# wet utilities CD sheets.pdf Markup Summary

SHEET NUMBER
UT2

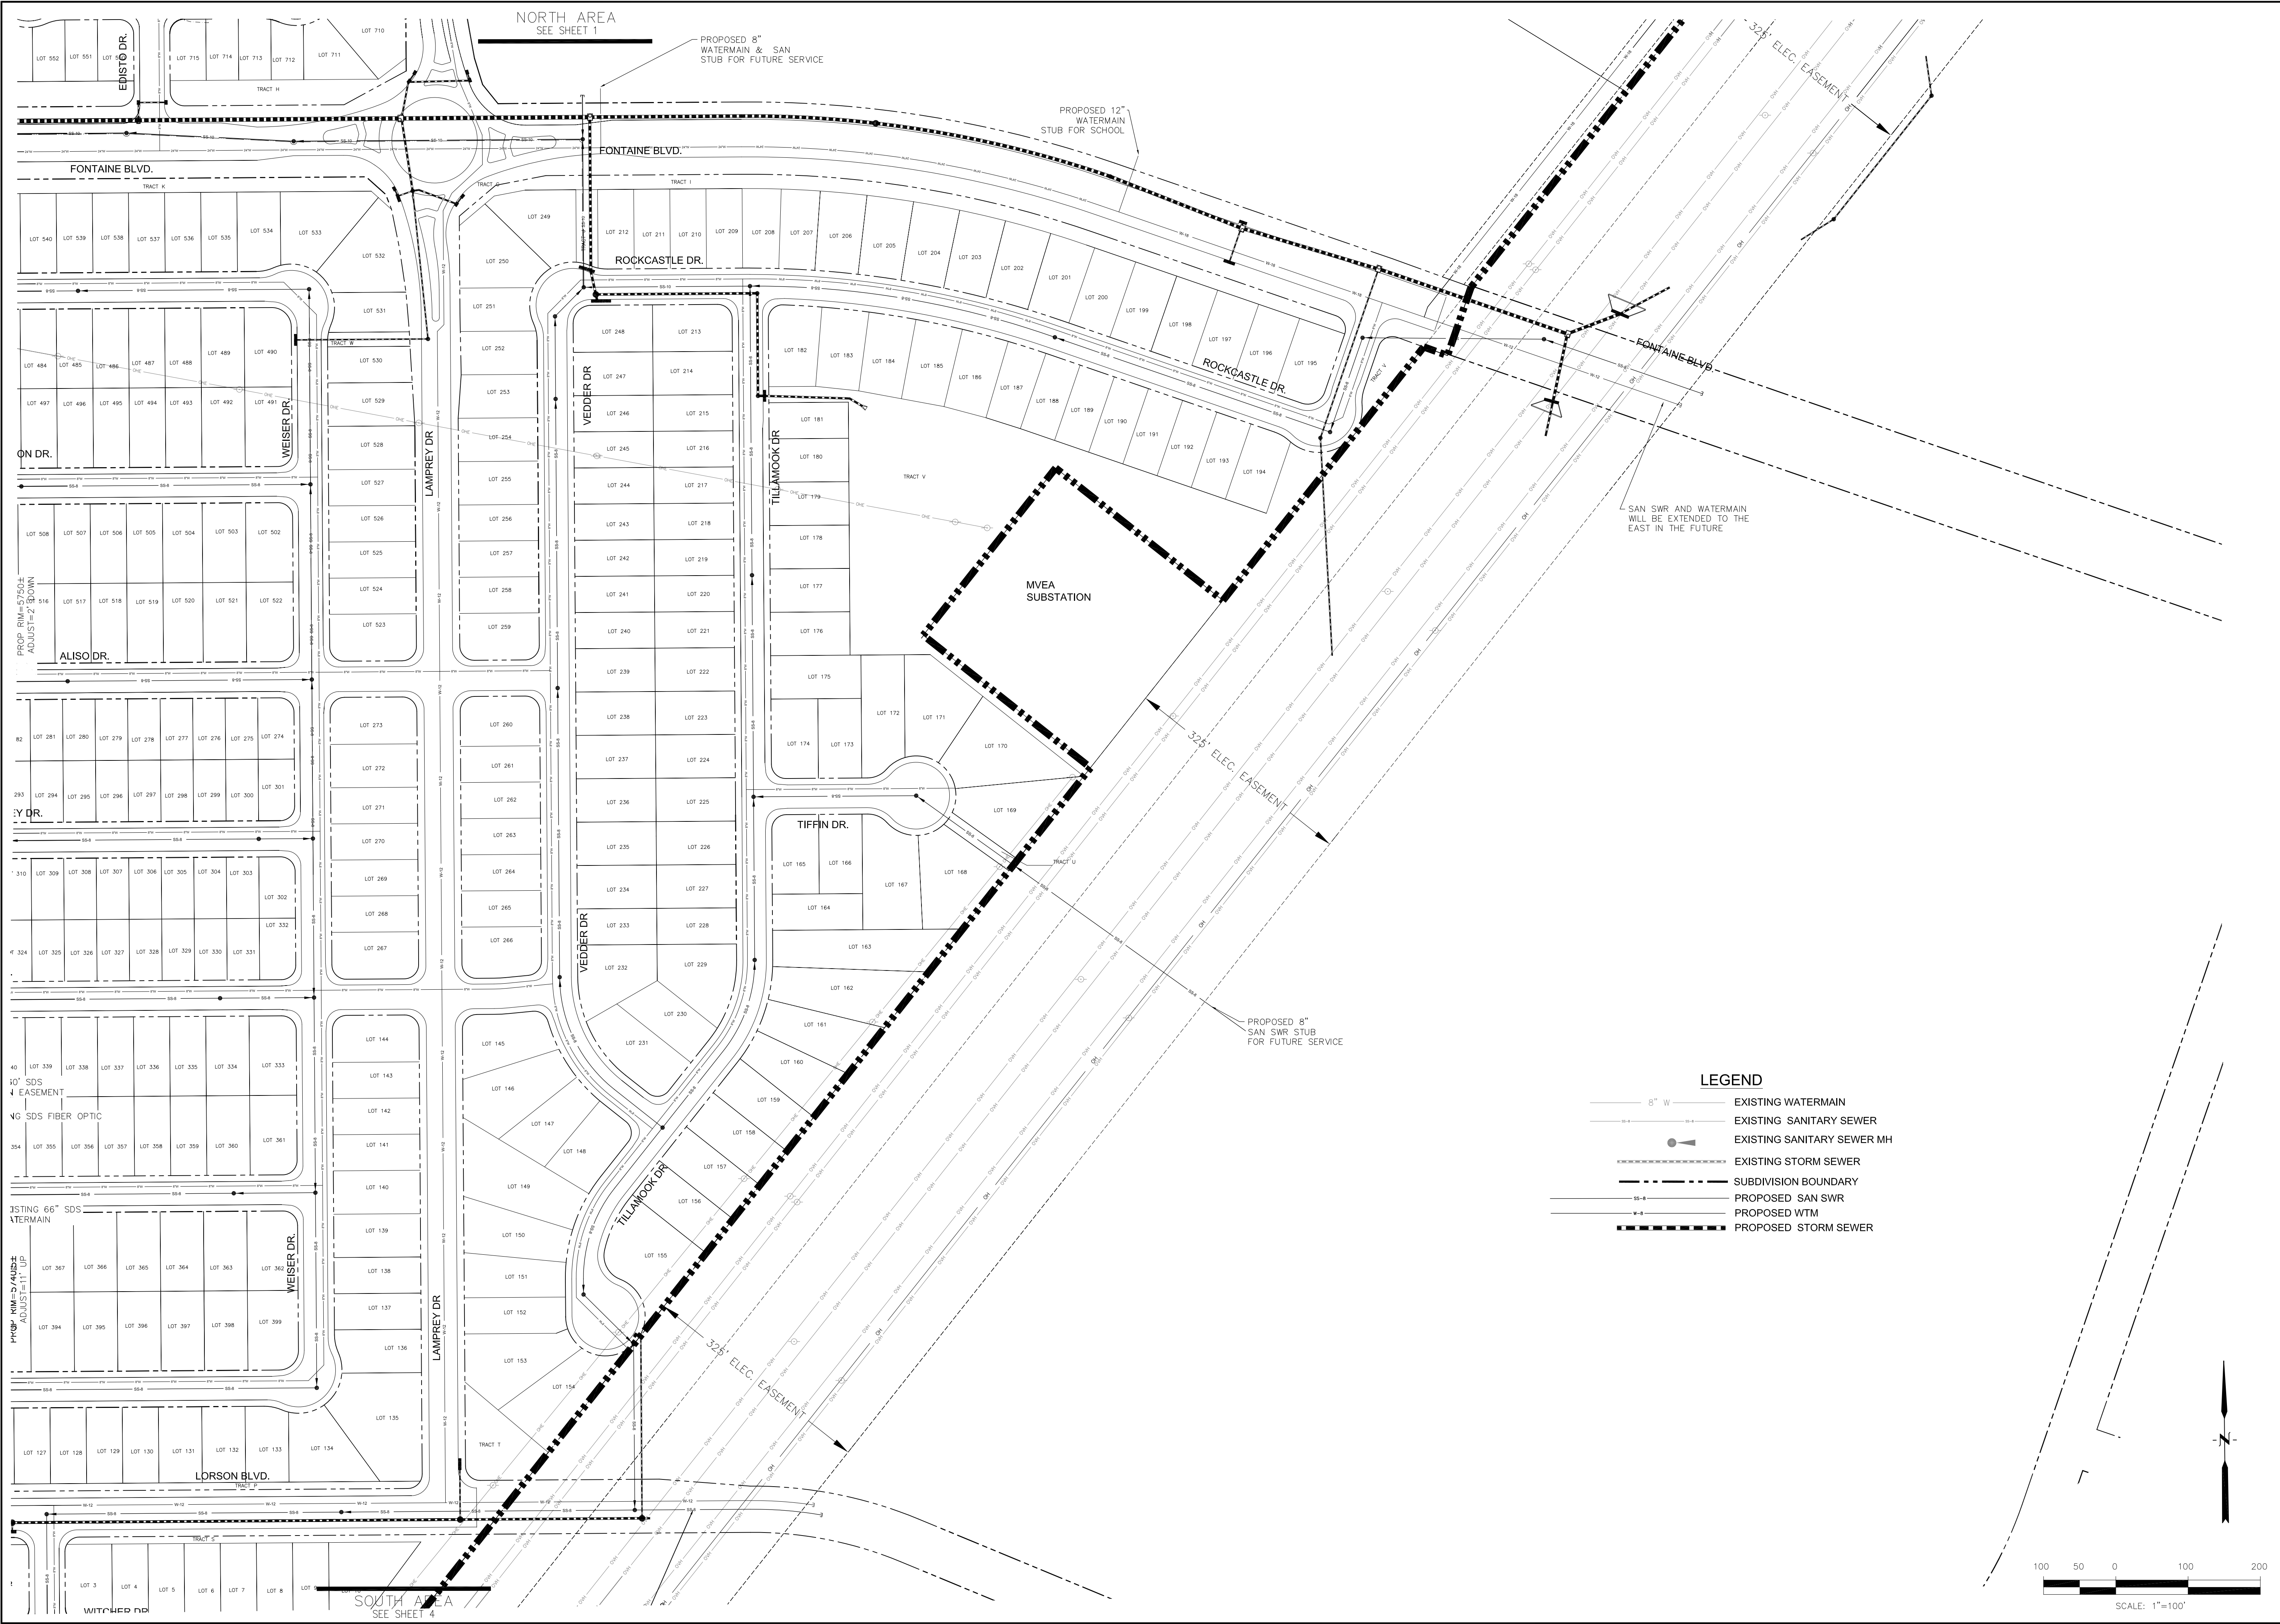
North?
